**Request for Advice – 50-52 Phillip Street New Hotel Stage 1 Concept DA (SSD-10464)**

Thank you for your correspondence dated 13 April 2021 requesting for the City of Sydney Council (“the City”) to comment on the abovementioned State Significant Development application. The proposal relates to the Stage 1 concept proposal for a hotel and residential development on the site.

The accompanying documentation has been reviewed. The City raises significant concern regarding the impacts of the proposal. The proposed intrusions of the development to state heritage buildings within and in its air space are extensive. The development will create an undesired precedent, contrary to the overall objectives of heritage conservation of highly significant heritage buildings. **Accordingly, the City objects to the proposed development.** The following matters are raised:

### Proposed Podium

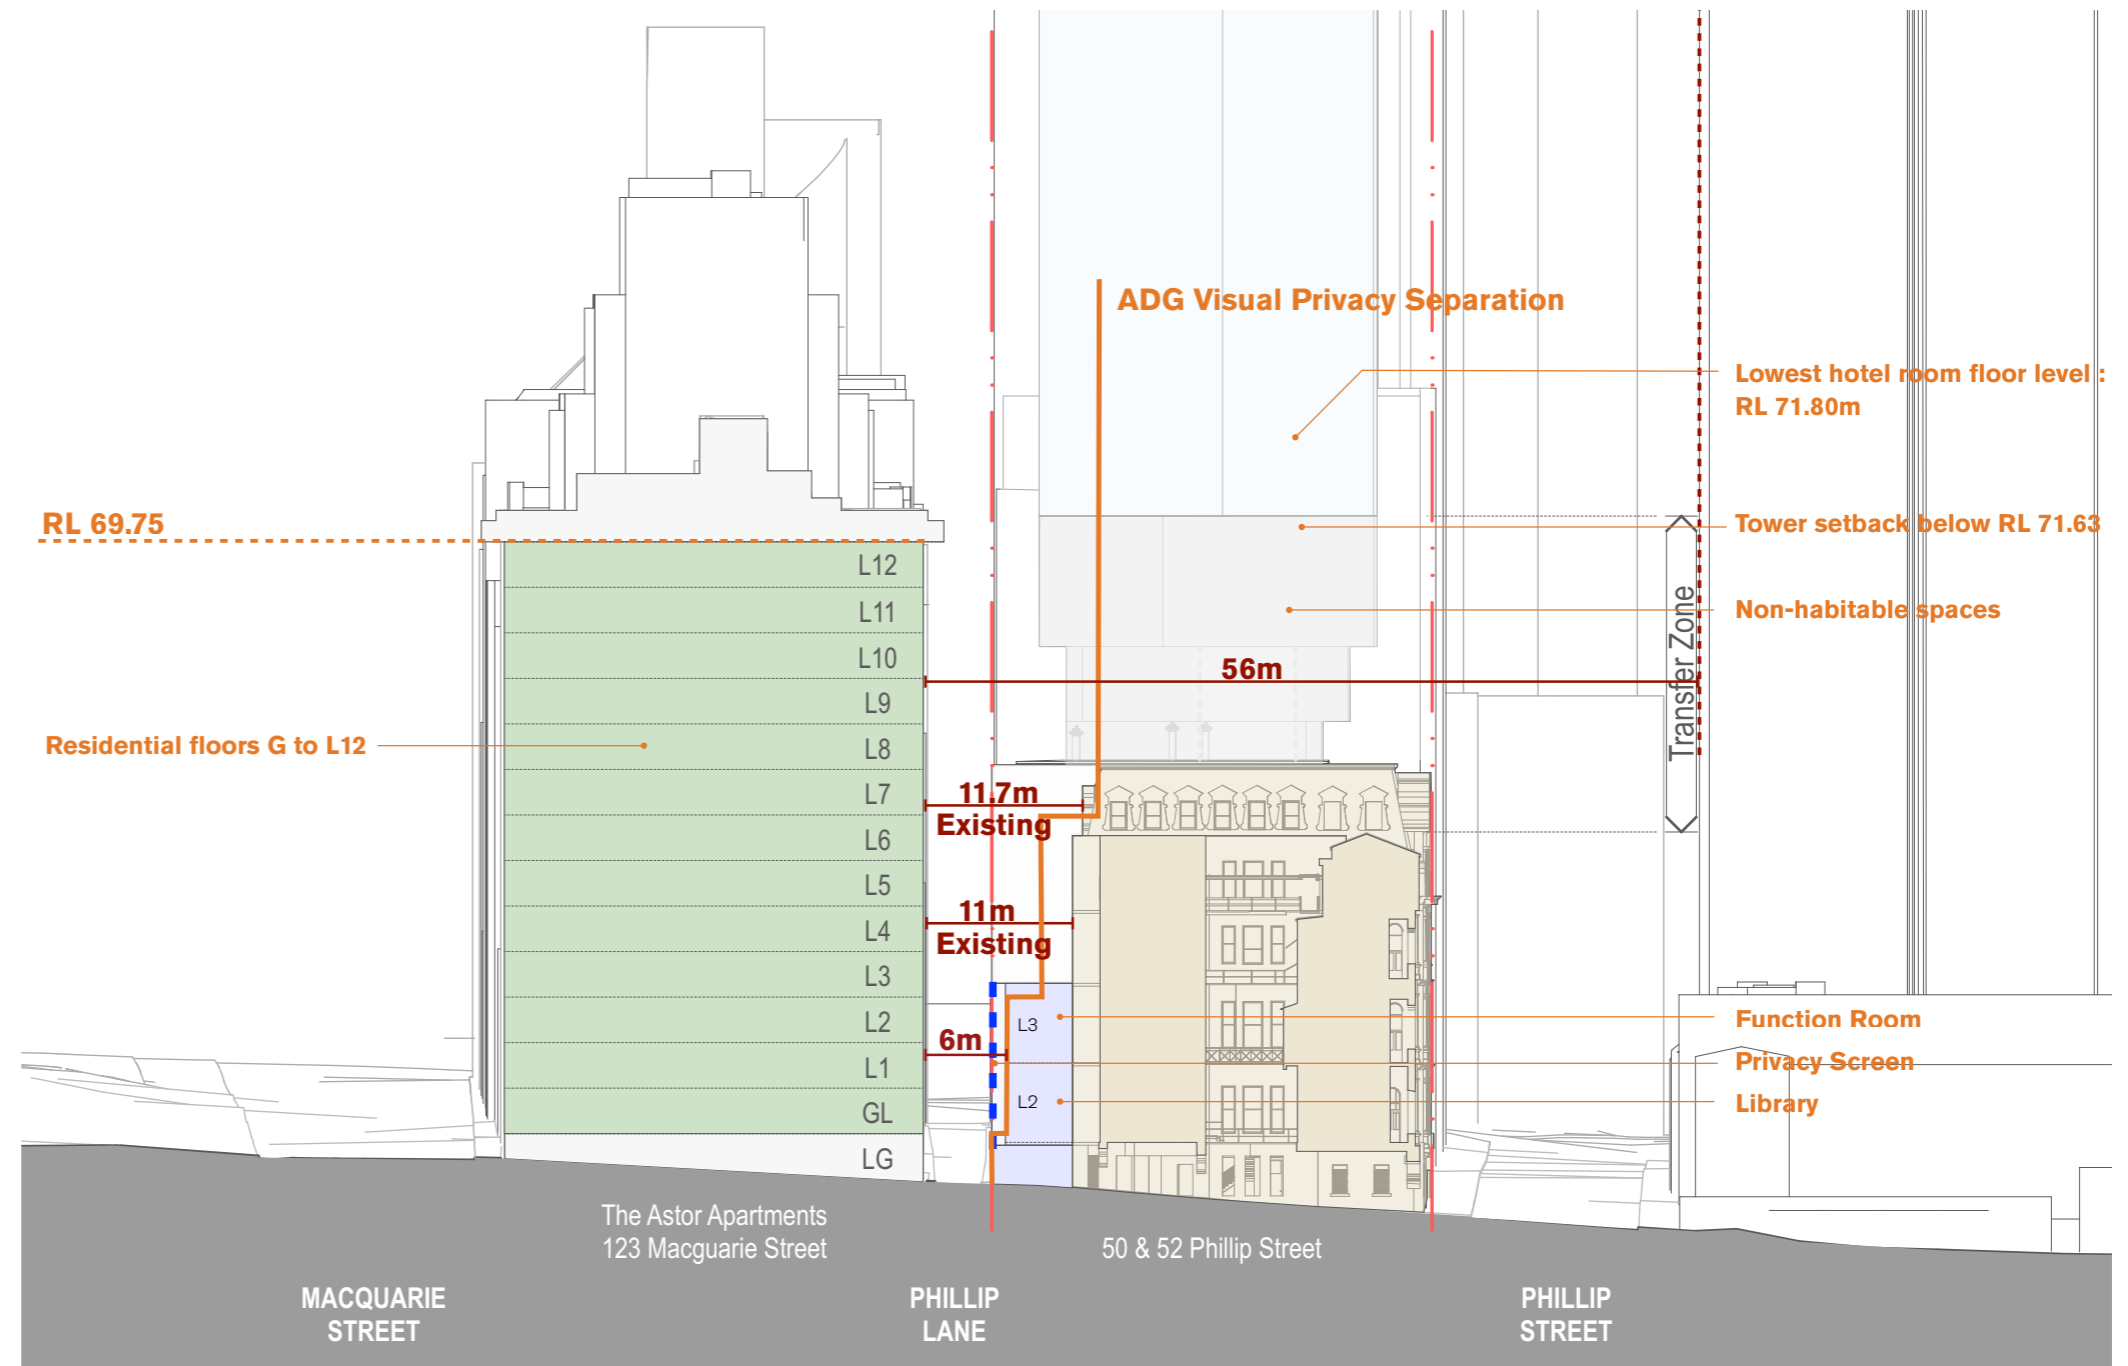
The 3-storey addition along Phillip Lane should be deleted and the eastern wall of the 1889 addition, which is identified to have high significance should remain evident on Phillip Lane. The southern lightwell and the southern wall of the wing should be retained at all levels to maintain the separation between the heritage site from 52 Phillip Street. The extent of physical integration of heritage building with the new building at 52 Phillip Street should be reduced to maintain the independence and integrity of the heritage structure. The interconnections of the two buildings should be constrained to the new openings on the southern boundary.

The proposed addition behind the PWB along the lane and the removal of the southern lightwell would considerably alter the streetscape of the lane at its northern end. The back windows and walls of the heritage buildings are obscured, and the characteristic back courtyard is removed under the proposal.

Both the new driveway and the drop-off area have considerable impact on the scale and historic form of the laneway. One of these aspects must be deleted to reduce the intervention to the lane. The 3-storey addition along Phillip Lane should be deleted and the eastern wall of the 1889 addition, which has high significance, should remain exposed to Phillip Lane. The southern lightwell and the southern wall of the wing should be retained to maintain the separation between the heritage site from 52 Phillip Street.

**Indicative Design Plan - Level 35 Swimming Pool**

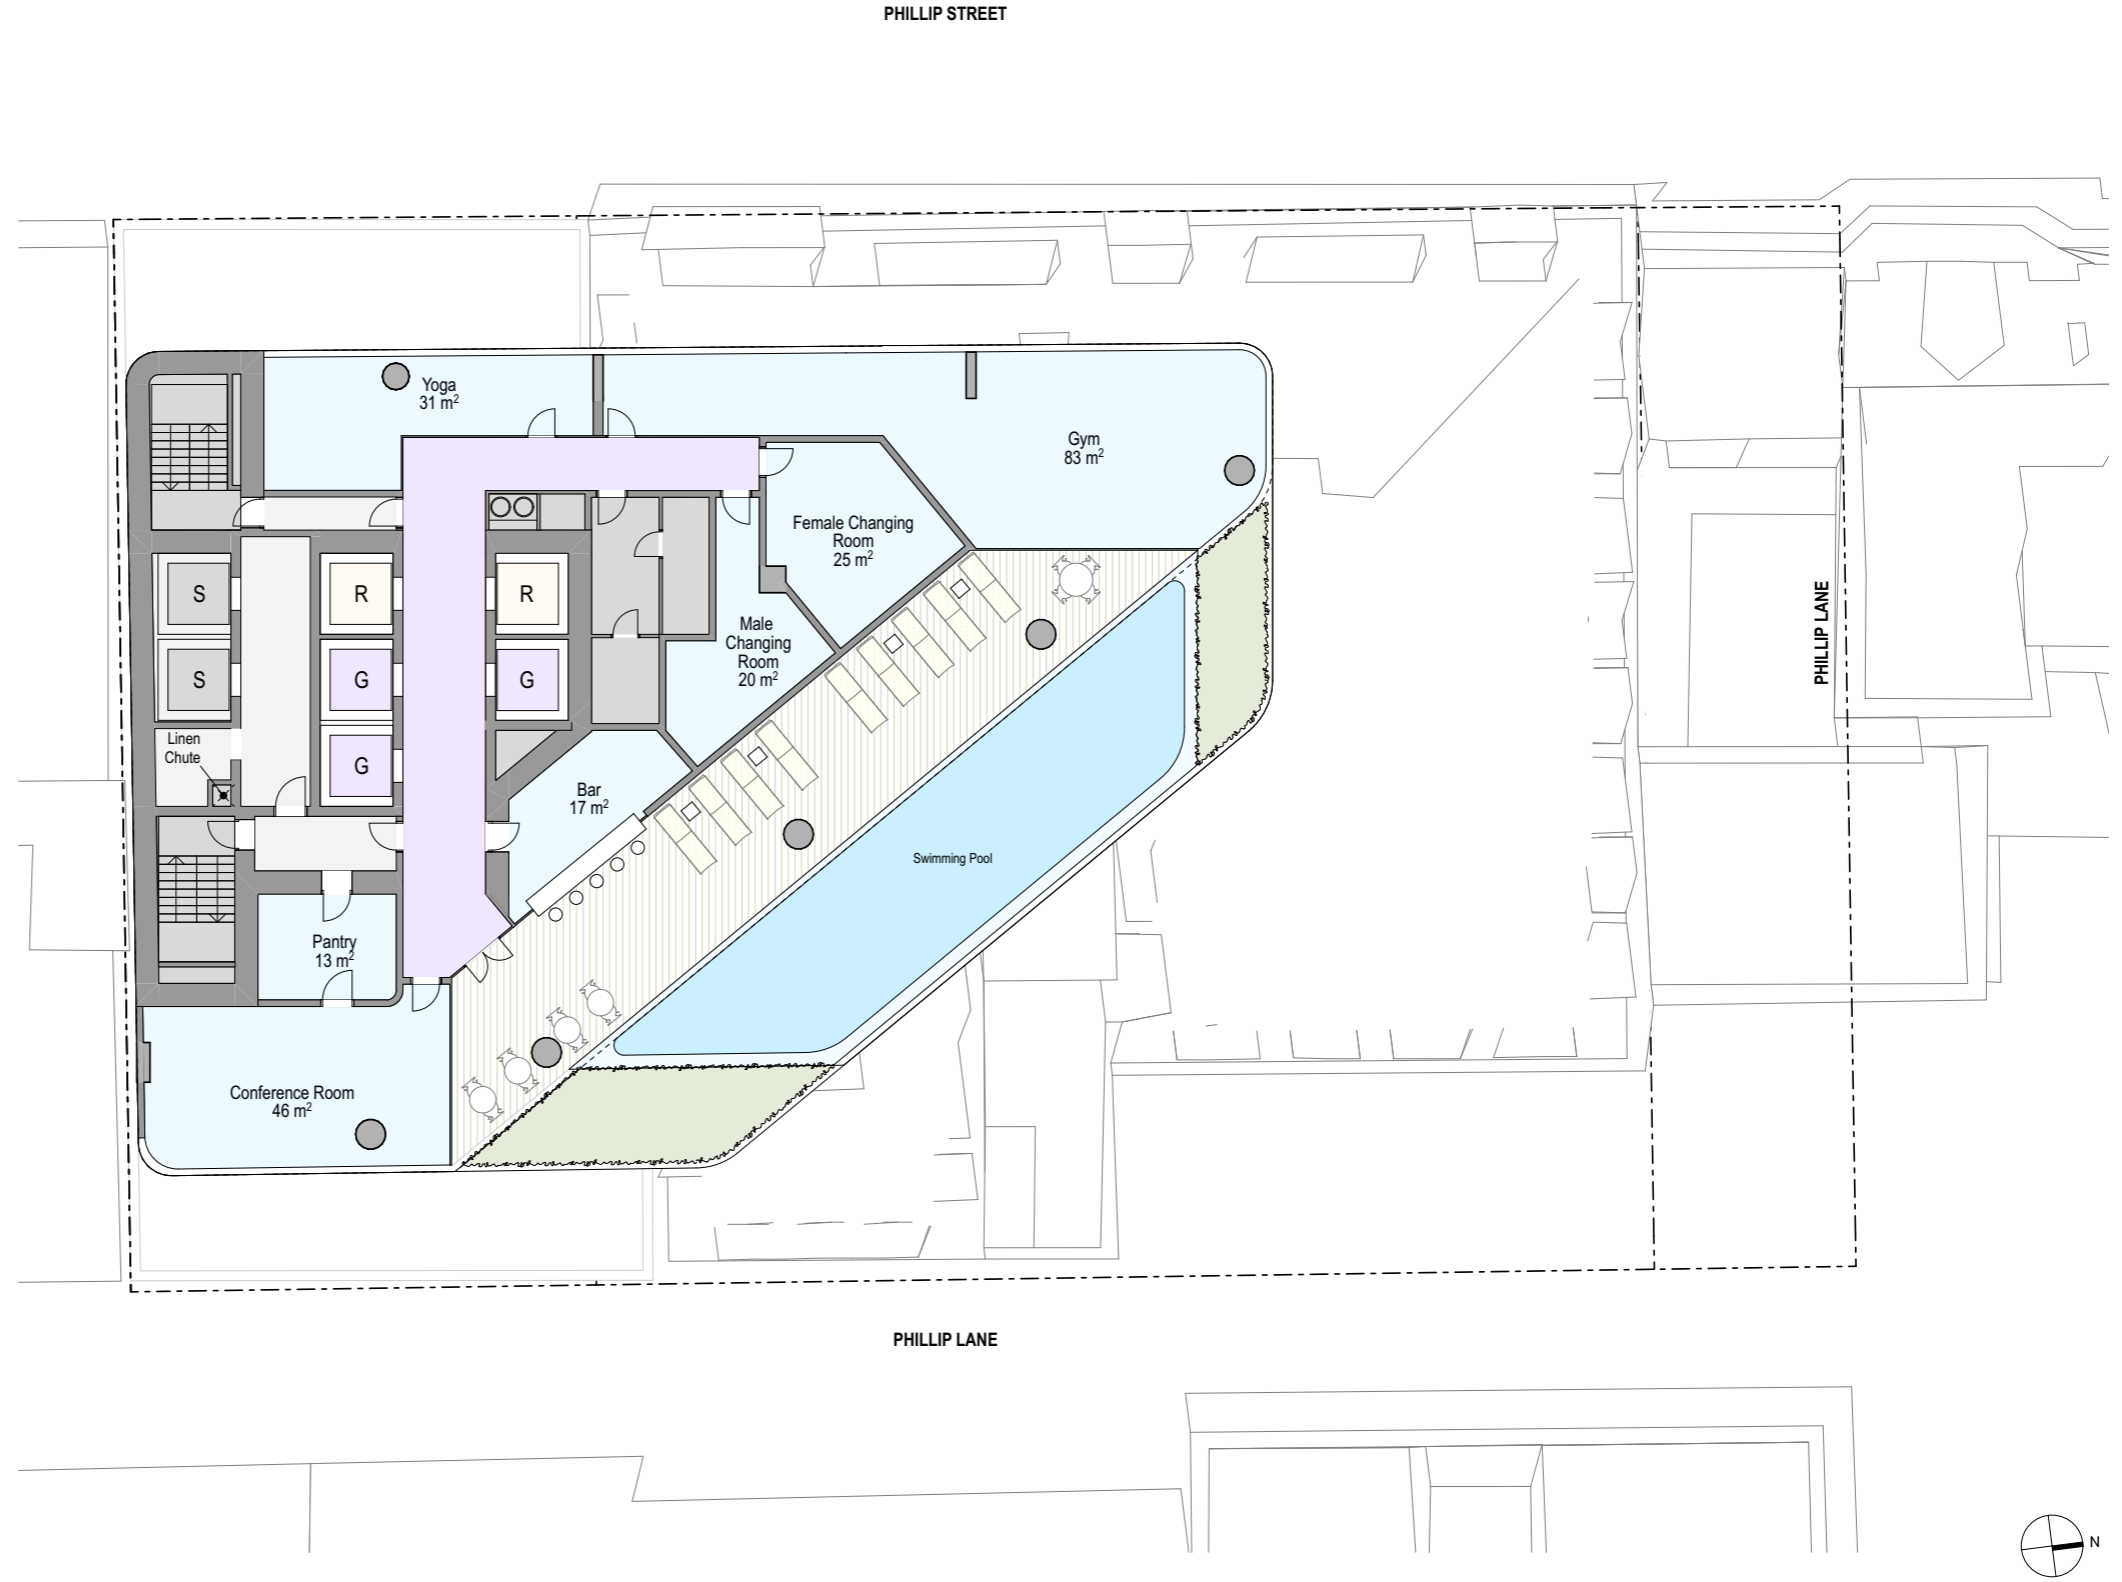
It is unclear in the indicative architectural plans as to whether the area on Level 35, that is indicated as hotel amenities and common open space for the residential uses, is enclosed. Consideration must be made in the wind assessment for the comfort levels of this area in the development to ensure it is fit for purpose and would not be unduly affected by wind.

**PROPOSED ENVELOPE - TRANSFER ZONE RL 71.63m**

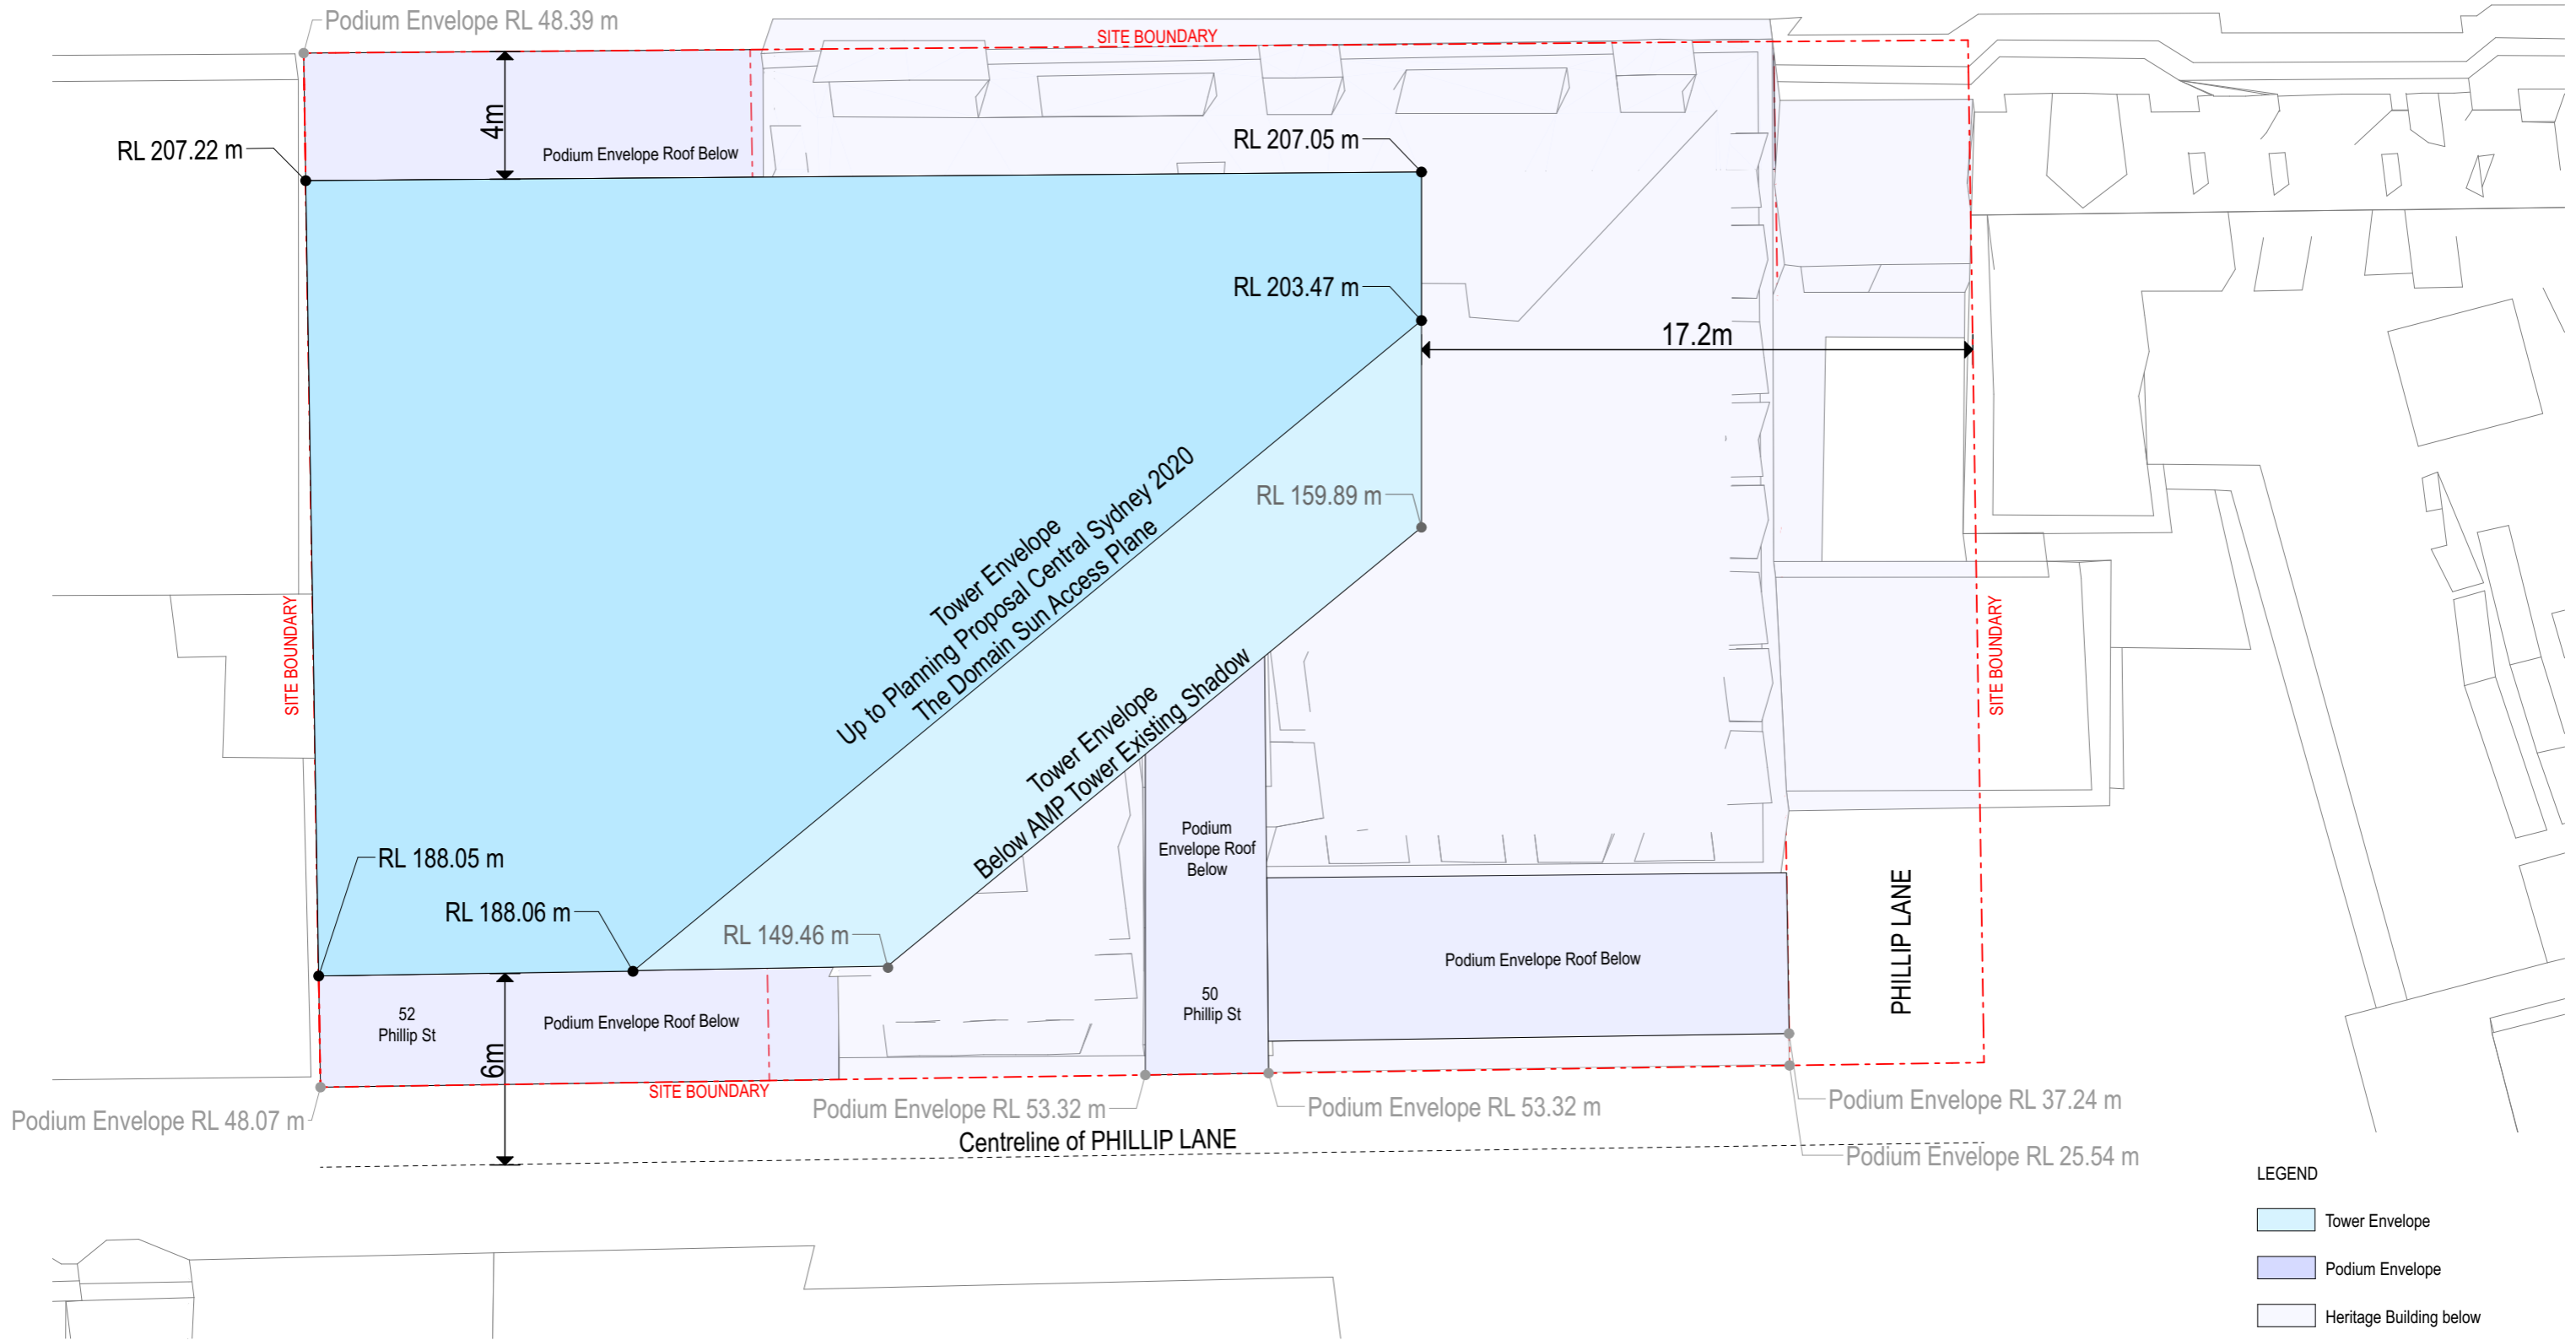
The top crest rail of the mansard roof has a height of RL 54.71, and the roof also has a chimney on the southern boundary with a height at RL 56.7. The stepped projections under the proposed building envelope is RL56.52, RL62.03 and RL71.63. The starting point of the projection conflicts with the chimney and is very close to the top of the existing roofline.

The extent of overhang is around 21 metres and constitutes two thirds of the frontage of the heritage building. The transfer zone height is approximately 5 metres. The transfer zone height is small in comparison with the overhang length. Due to the extent of the overhang, insufficient setback from Phillip Street and the proximity of soffits of the overhang to the heritage roof, the new tower would overwhelm and impose over the PWB.

The extent of overhang should not be more than half of the frontage length of the heritage building (approximately 16 metres). The gap of the overhang and the heritage roof is to be increased. The starting point of the projection from the boundary should not be less than 3 metres above the chimney at RL56.70. The angle of the overhang soffit is to be increased to 60 degrees.
